2024/0768**Address:** 1 South Croft, Shafton, Barnsley, S72 8QL**Description:** Raising of eaves and ridge height to accommodate rooms in the roof space of single storey detached dwelling.

FRONT ELEVATION

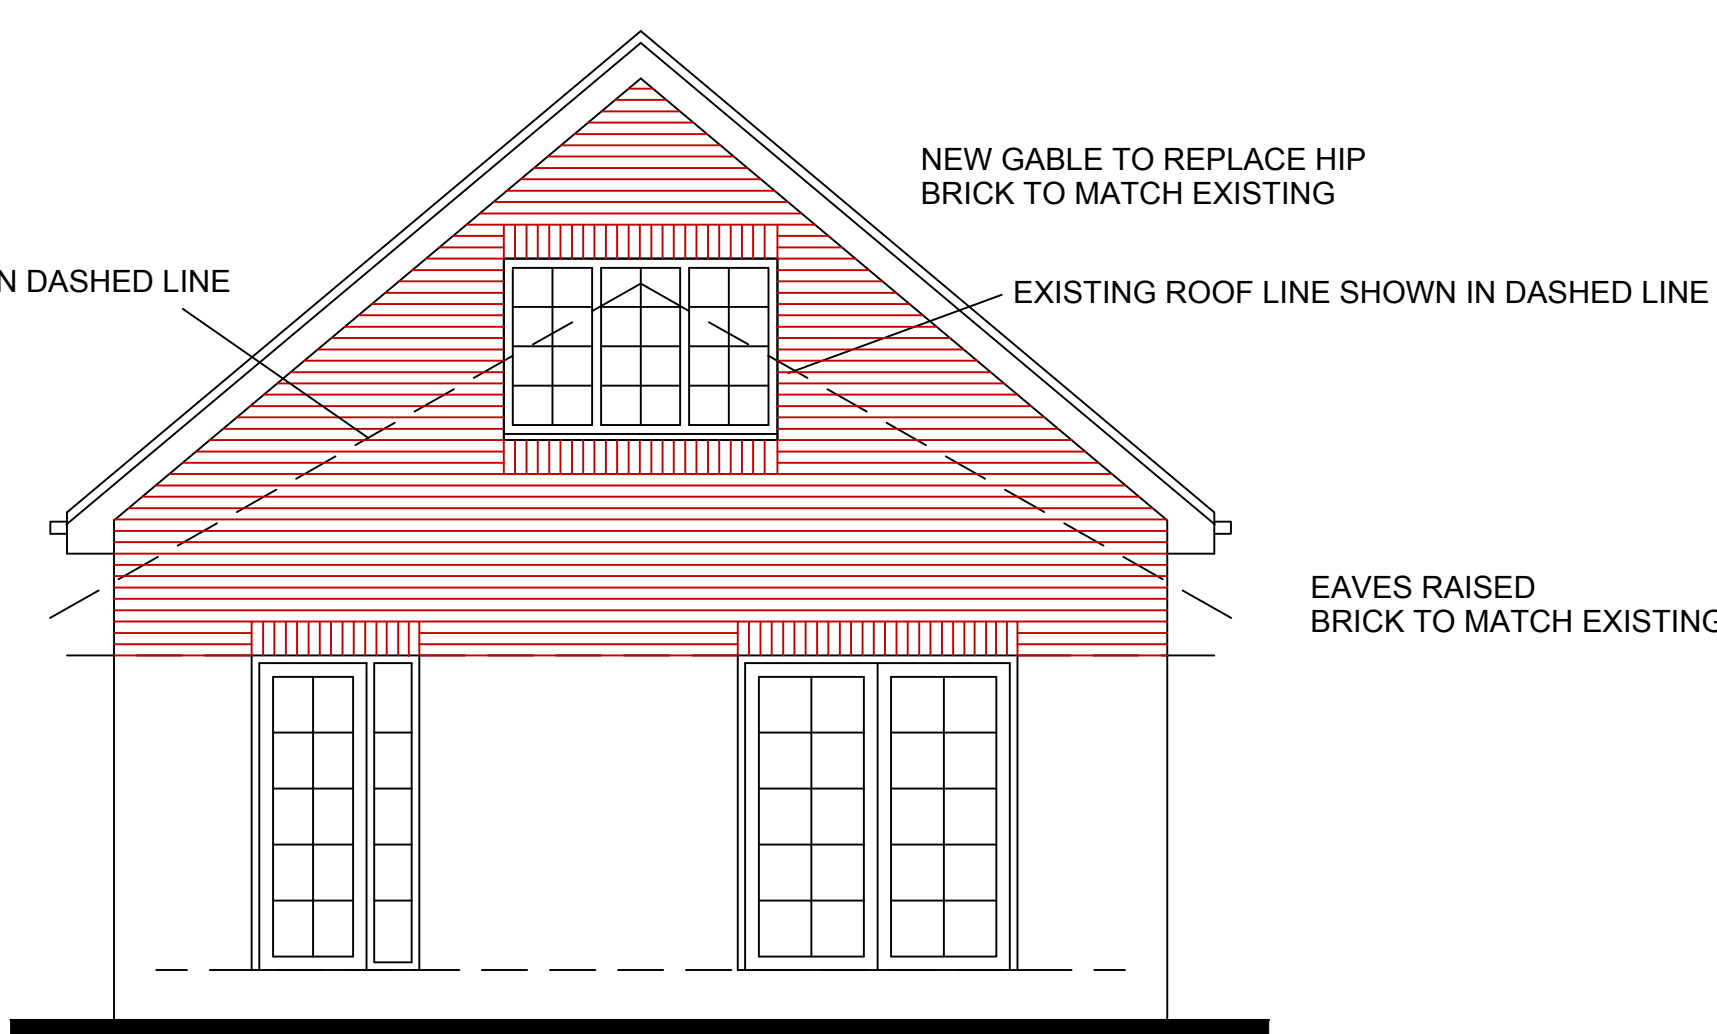
Starting with the concerns raised by residents of South Croft, their main issue is the impact on their privacy caused by the proposed first floor window of the front elevation overlooking their dwellings. However, the separation distance of approx. 22m exceeds the minimum requirement of 21m outlined in the SPD 'House Extensions and Other Domestic Extensions'. Regarding the concerns raised by a neighbour on Ashwell Close, in regard to loss of light, potentially, there may be a slight impact upon the light levels at certain times of day in regard to light levels in their garden but overall due to the limited size of the roof expansion and distance to their actual dwelling, the impact would be considered modest and would not have a significant impact on their amenity.

REAR ELEVATION

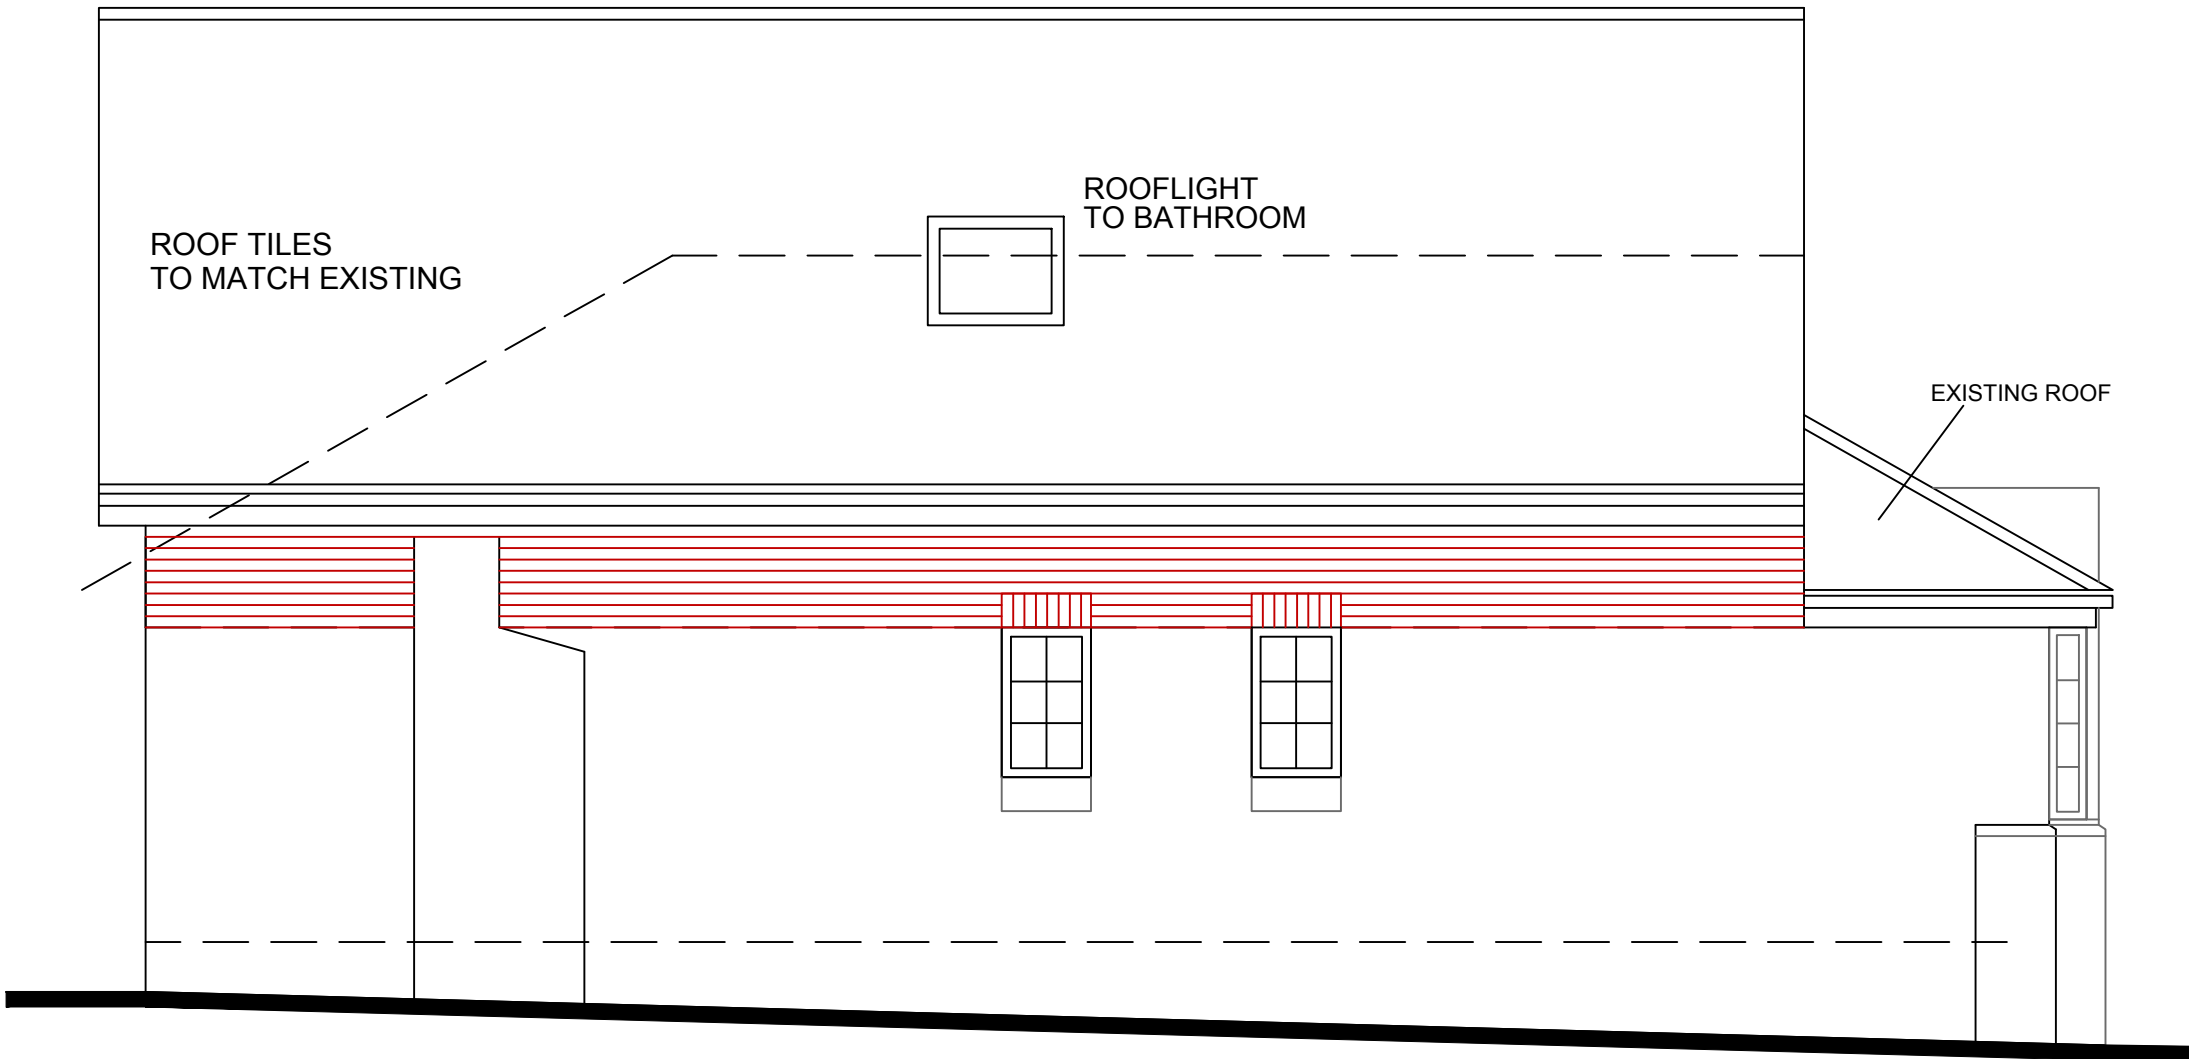
For the second neighbouring dwelling of Ashwell Close who raised an objection, their objection mainly relates to the proposed first floor rear window within the raised roof. The side and rear curtilage of the application dwelling borders six curtilages across South Croft and Ashwell Close and although not in this application, has the potential to impact a further two curtilages on Meadow Croft. With a relatively compact rear garden, especially in contrast to their larger front garden, any development at the dwelling or within their rear garden would undoubtedly have some impact on the amenity of neighbouring dwellings to the rear and side of their dwelling. Whilst the rear proposed first floor window would be more than 21m from any directly overlooked window, and more than 12m from directly over looking any blank elevation, the distance from the window to the rear boundary of the garden is only 7.68m. The SPD recommends new first floor windows to have a minimum distance of 10m to the rear boundary. However, in this case, due to the location and orientation of the neighbouring dwellings, the privacy of the neighbour's dwelling is not a significant concern as it is not directly behind the applicant's property and therefore any views out of the rear window to the neighbouring dwelling would be at an angle rather than directly overlooked. The main area of overlooking would be the rear portion of the neighbour's garden. If the application dwelling's rear boundary was 2.15m further into the neighbour's garden, it would meet the SPD guidance. Because the boundary treatment is not in that location, there is in effect an area of approx. 15.5 sqm of the neighbouring garden which would be affected because of the boundary location being where it is. In contrast, the neighbour's rear garden is around 165 sqm, whilst their own rear extension takes up around 14 sqm and their outbuilding around 16 sqm, finally in a straight line from the boundary with the application dwelling to their other side boundary is 10.5m, wider than the longest length, and wider than the whole width of the application dwelling's rear garden. On balance, given the main area of overlooking is to the very rear of the neighbour's rear garden, and not directly into their property, it is not considered that the proposal would have a significant detrimental impact on neighbouring amenities to warrant refusal of the application. Given the works involved, and the area of land within the applicant's curtilage there is the potential for any further outbuildings/extensions to create an over-developed site which would also impact on neighbouring amenities. As such, it is recommended that permitted development rights for further extension or any outbuildings are removed by condition.
